KITTITAS COUNTY DEPARTMENT OF PUBLIC WORKS

MEMORANDUM

TO: Jeff Watson, Community Development Services
FROM: Christina Wollman, Planner II *CW*
DATE: October 23, 2013
SUBJECT: Widner BL-13-00027

ADAMS CLUSTER SHORT PLAT  
PART OF SECTION 20, T. 18 N., R. 19 E., W.M.  
KITITITAS COUNTY, WASHINGTON

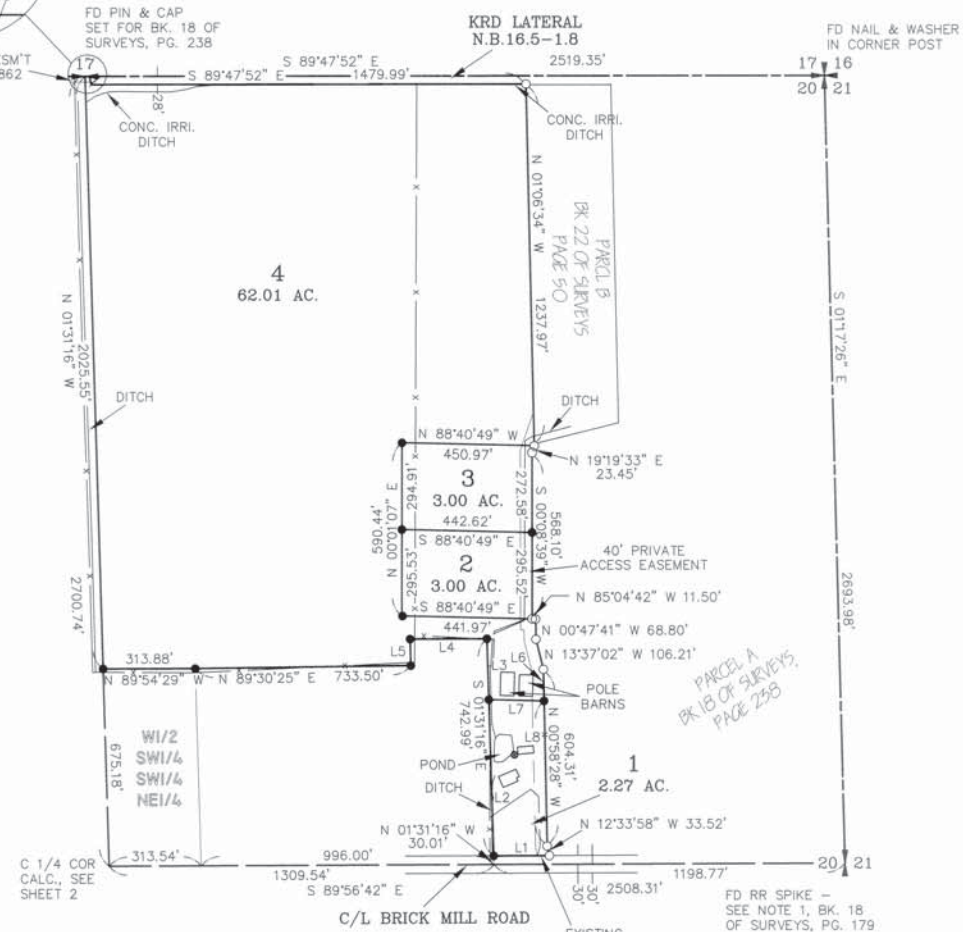
1. A revised legal description that describes the final configuration of the subject property shall be required.
2. An access easement shall be provided to Lot 4, if one does not currently exist.
